**TO:** Stand Sure Homes  
**PROJECT #:** 23-1247-A  
**PAGE:** 1 of 1  
**DATE:** January 26, 2024  
**LOCATION:** Wilborn Residence  
**PLAN REF:** Wilborn Residence by K&A Home Design  
Project# 23-1247

**THE FOLLOWING CHANGE(S) OR PROPOSED CHANGE(S) LISTED BELOW ARE DEVIATIONS OR CLARIFICATIONS FOR THE ABOVE REFERENCED PLANS:**

ROOF STRUCTURAL PLAN

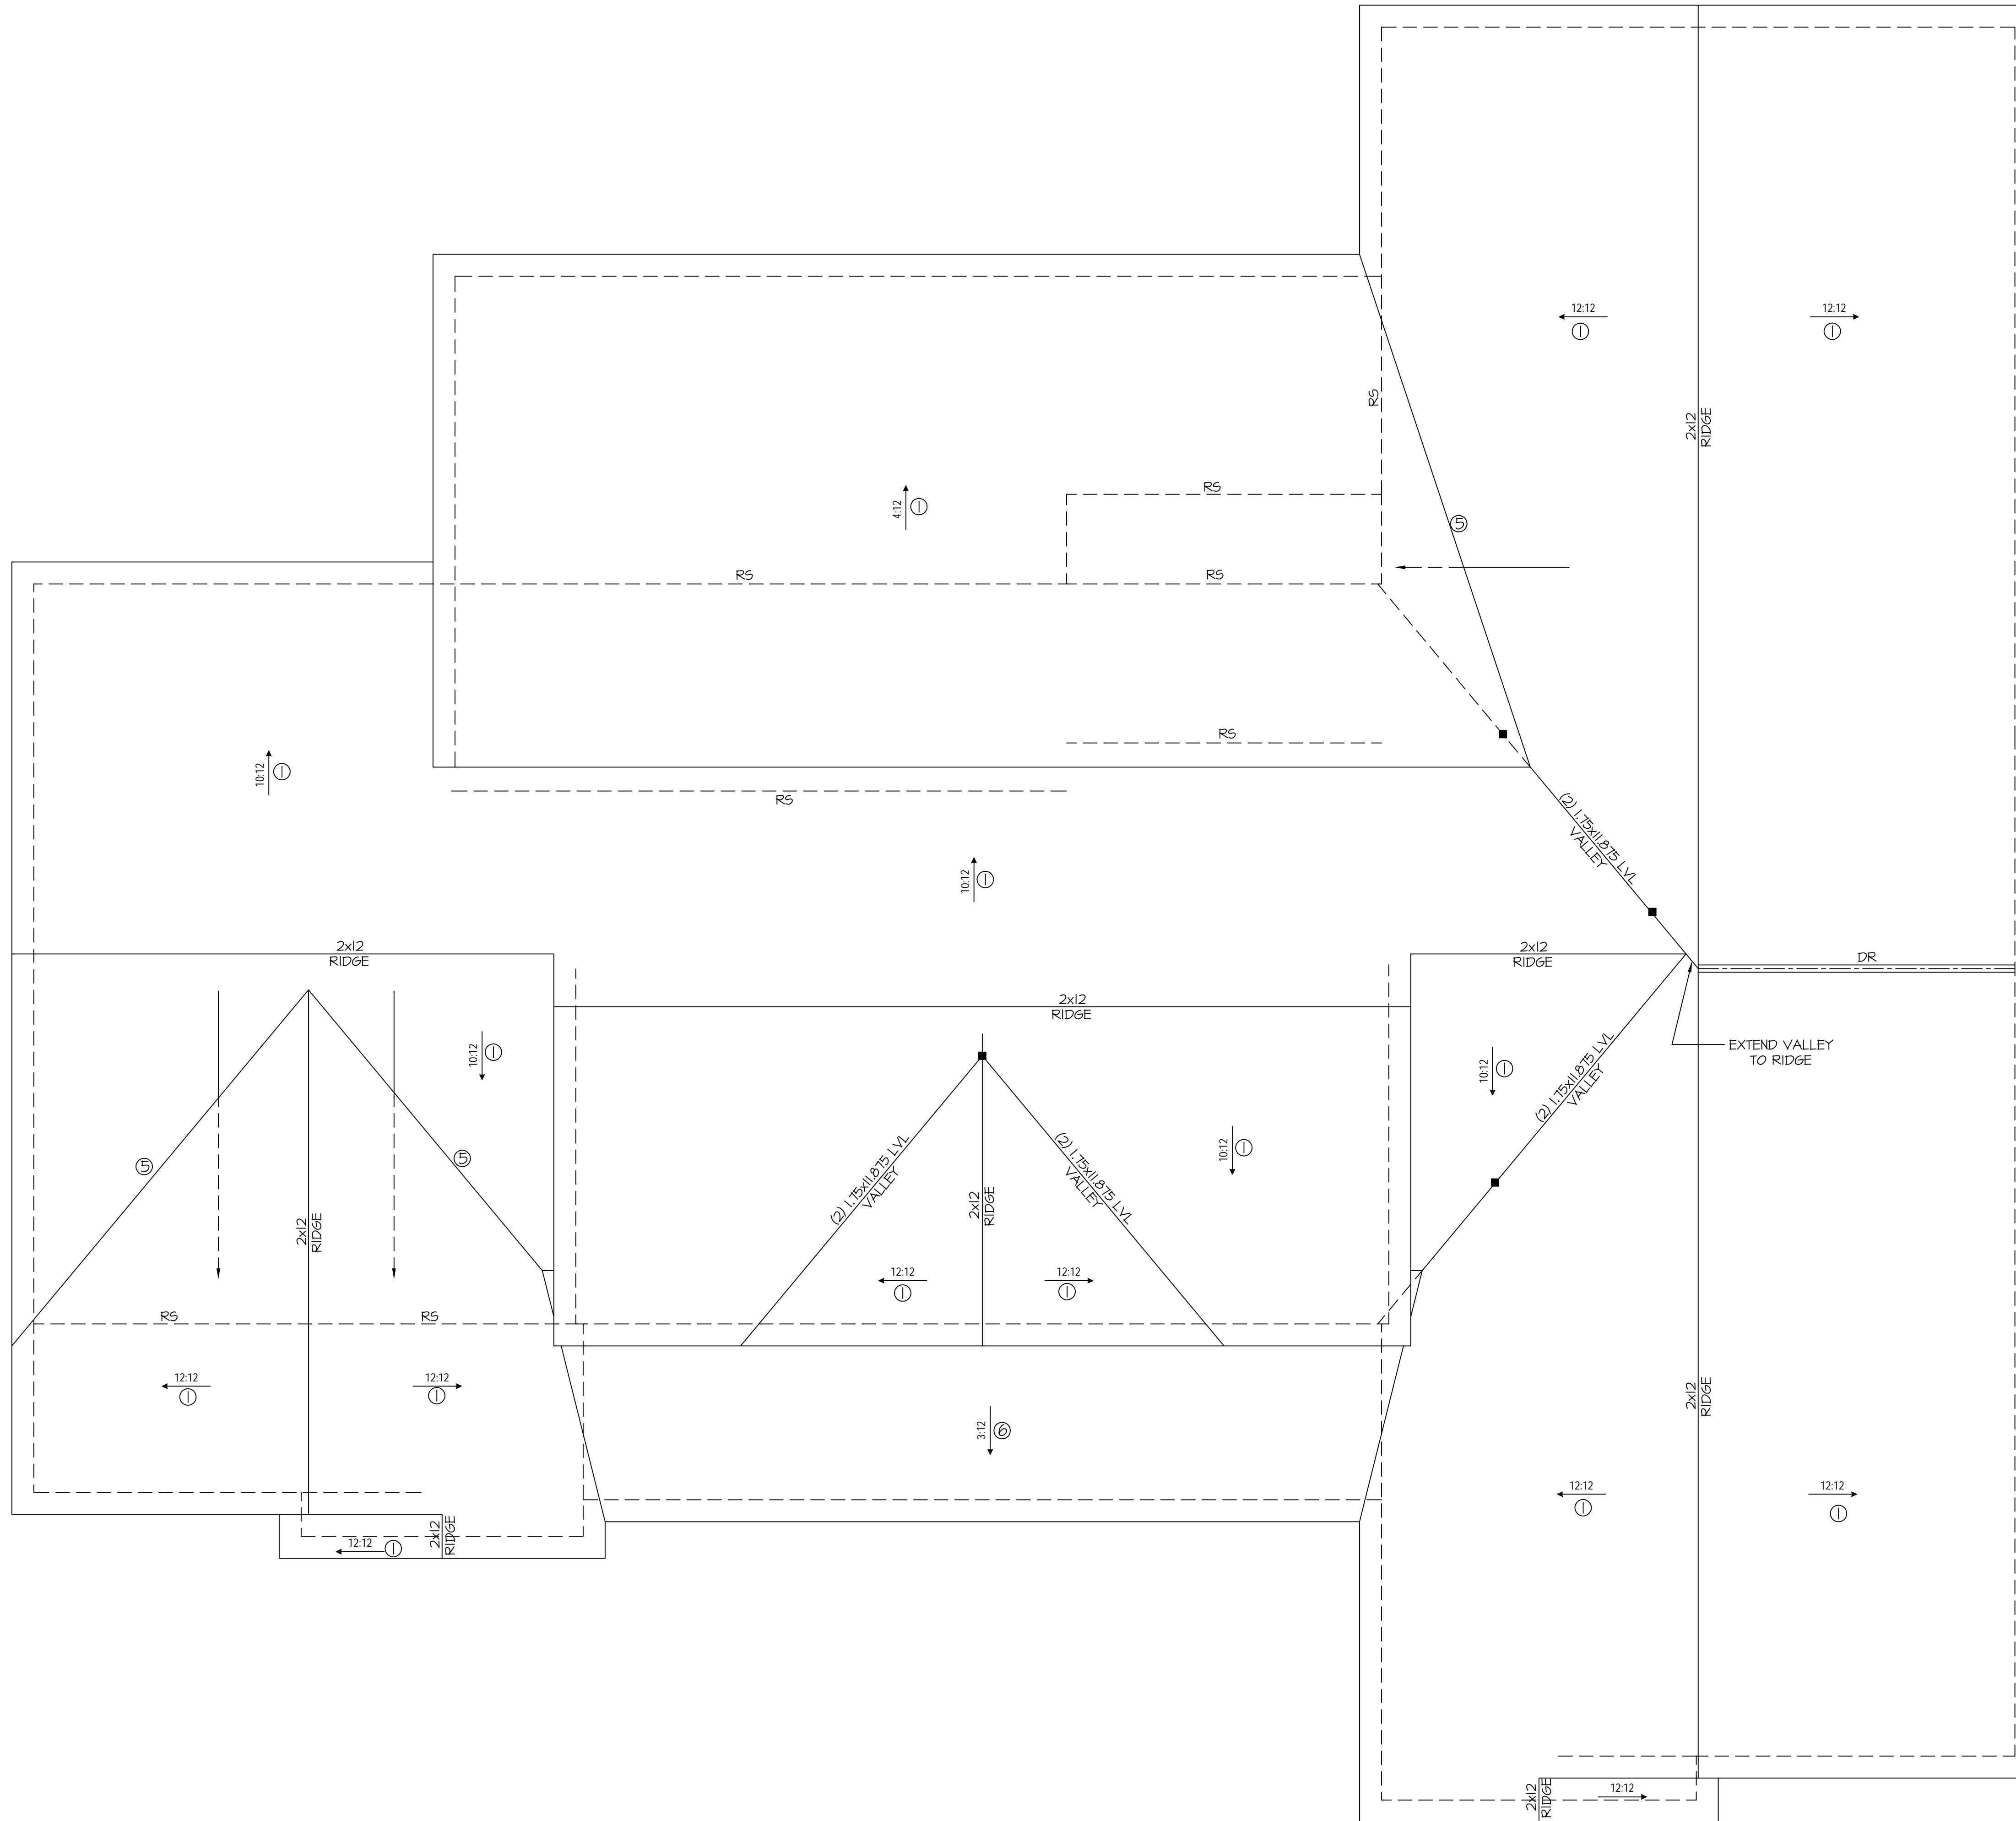
Extended LVL Valley: The original plan as shown in the Roof Structural Plan (S-4), includes a valley structure made up of two (2) 1.75 x 11.875 LVL's. These are located on the rightmost part of the roof. In the original plan, the far valley extends into the 2 x 12 ridge, while the near valley extends and is to be supported by the valley that extended into the ridge. Per information provided by the builder the near (2) 1.75 x 11.875 LVL was extended to the 2 x 12 ridge, and the far valley was adjusted to extend into and be supported by the near valley which now extends to the ridge. This valley structure is a reversal of what was initially shown. Additionally, the near (2) 1.75 x 11.875 that now extends to the ridge is supported with (3) 2 x 4 studs at the Front Closet wall.

**Response:** Please note the construction mentioned above is acceptable.
